From: Andrew Robley
Sent: 27 January 2017 18:05
To: Mark Peacock
Subject: FW: Northaw; The Oshwal Centre, Coopers lane Road; 16/1600LB

From: Andrew Robley
Sent: 27 January 2017 17:06
To: Mark Peacock <m.peacock@welhat.gov.uk>
Subject: Northaw; The Oshwal Centre, Coopers lane Road; 16/1600LB

This application is the same as that upon which I commented back on the 14/11/16 and although this application form refers only to window repairs, the heritage statement also includes stone repairs. I have therefore highlighted the parts that refer to the windows.

DRAWING TITLE  
 EXISTING ELEVATIONS

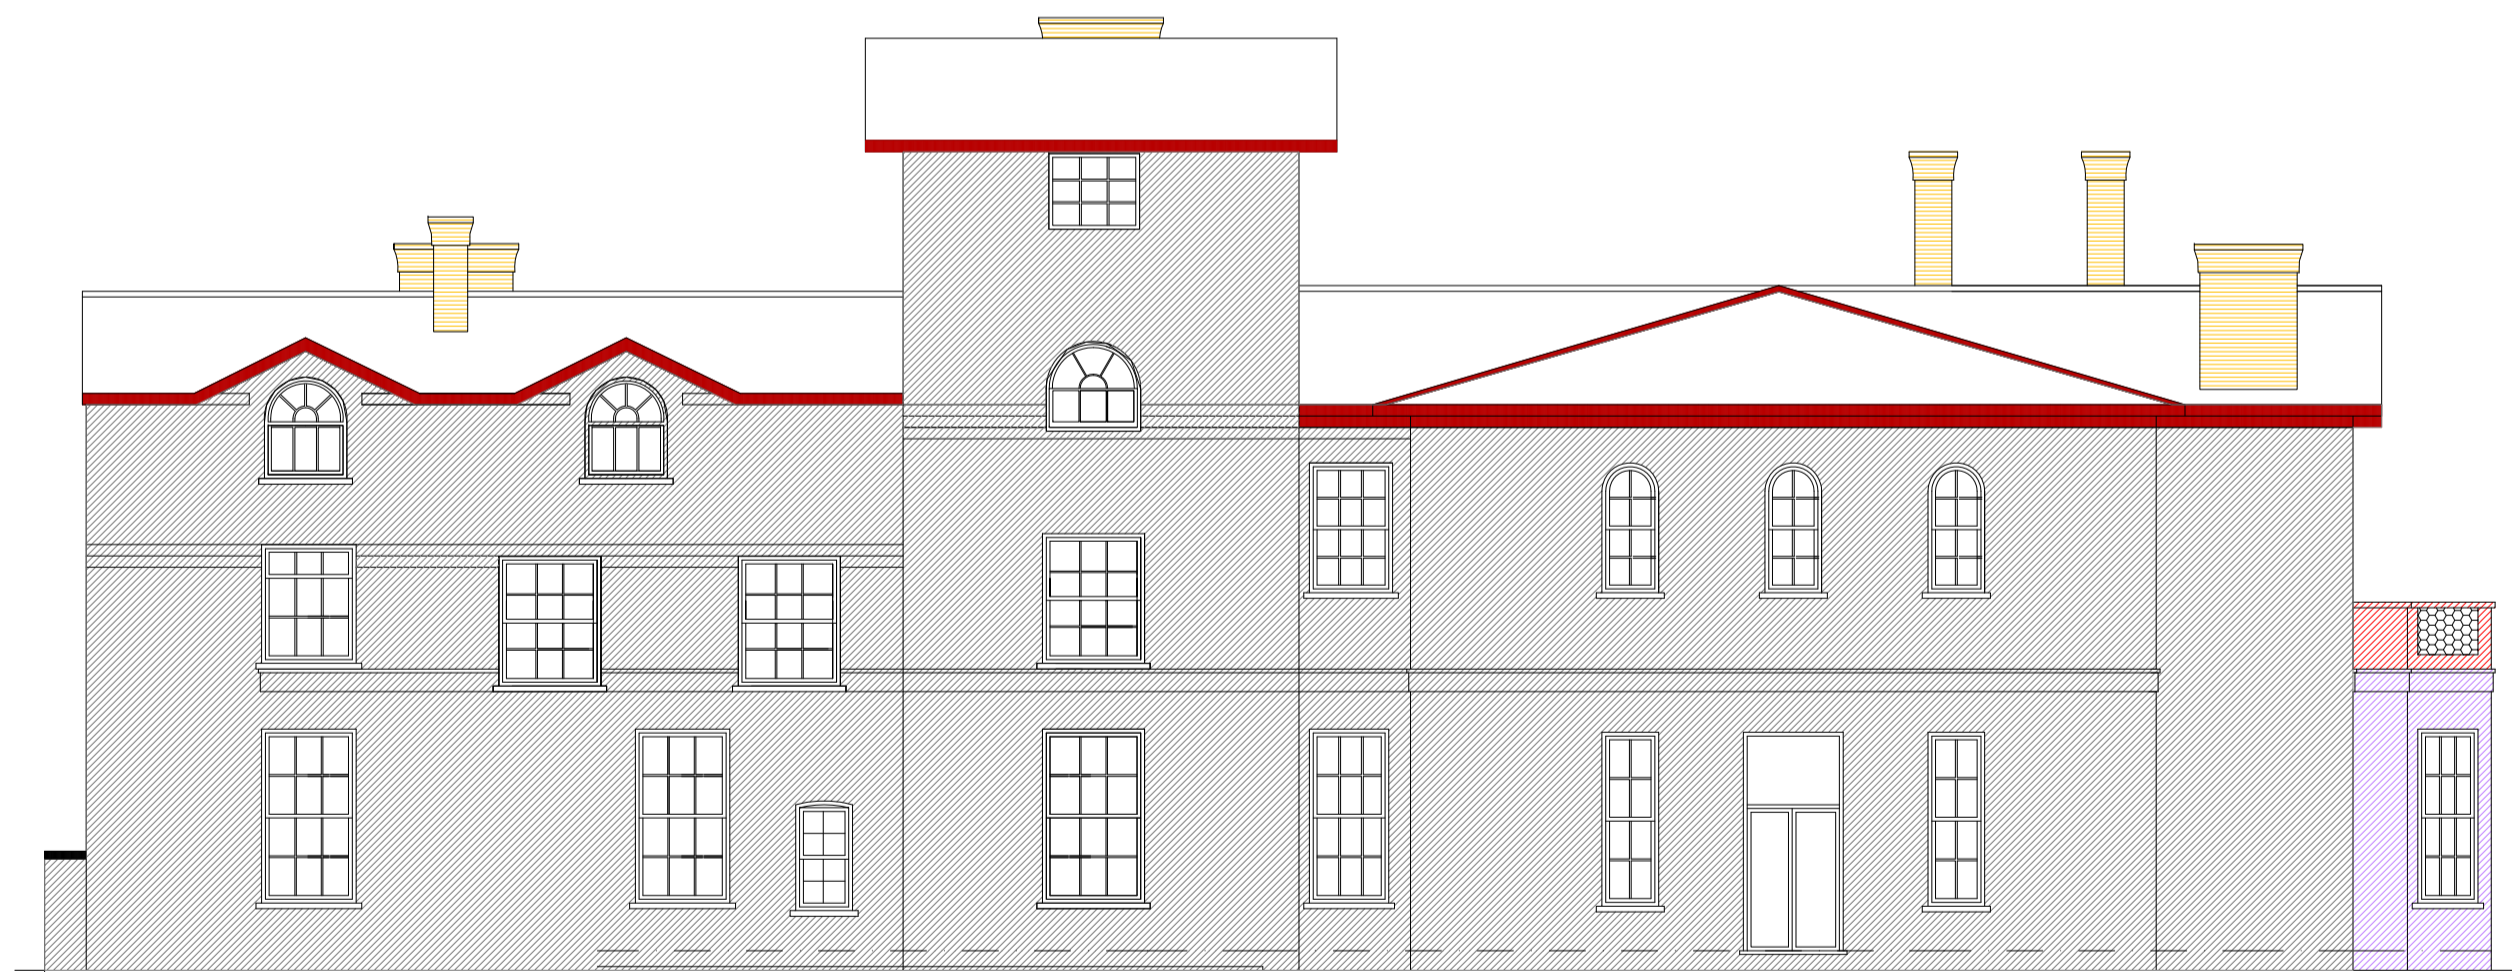
Some of the rendering is probably modern but it is not certain without proper investigation whether any remains original or whether there is original rendering under a modern cement based skin. The information supplied is deficient in that there is insufficient advice in this regard. What is evident from my site visit is that some of it is cracked and some distorted especially I near ground level and around sills.

To strip and replace all the render with cement based render using (presumably metal) beads and stops at corners.

Rendering: Painted stucco is also an essential component of many Regency Houses. It is important to retain original stucco where possible but it is not certain whether all or any of the current render is original stucco. The Heritage Statement offers no back up information as to the originality or not of the existing stucco but nevertheless, the proposal is to remove the whole lot. This would not be acceptable without evidence that it is all modern render and therefore not worthy of retention. However, it is clear that some of the render is defective and would at least need to be repaired. Nevertheless prior to this, there should be some analysis of the original render so that the repair can be compatible. Even it is established that it is modern cement, if this is then to be removed it would be a missed opportunity to replace it with cement render as specified in the schedule of works, because it tends to crack easily, and to trap moisture in the fabric, leading to further failure, damp penetration and decay of timber, whereas lime render or similar that would have been originally used is more permeable to moisture and allows dampness to evaporate and dry out . The proposed use of metal plaster stops and angles would be too sharp and not in keeping with the originally crafted corners.

The works should be reconsidered: A survey by a conservation accredited Architect or Surveyor should be a pre-requisite for works of this extent. The aim should be to retain all of the historic windows, repair and upgrade them if necessary in accordance with Historic England advice, using alternative, more conservative strategies for achieving better performance and greater longevity of paint systems. Original render (if any should be conserved) and any replacement render should

be compatible with any surviving original stucco or else good historic rendering practice and cement should not be used either in the render or any repointing . The causes of dampness and decay need to be properly established prior to specifying any work.
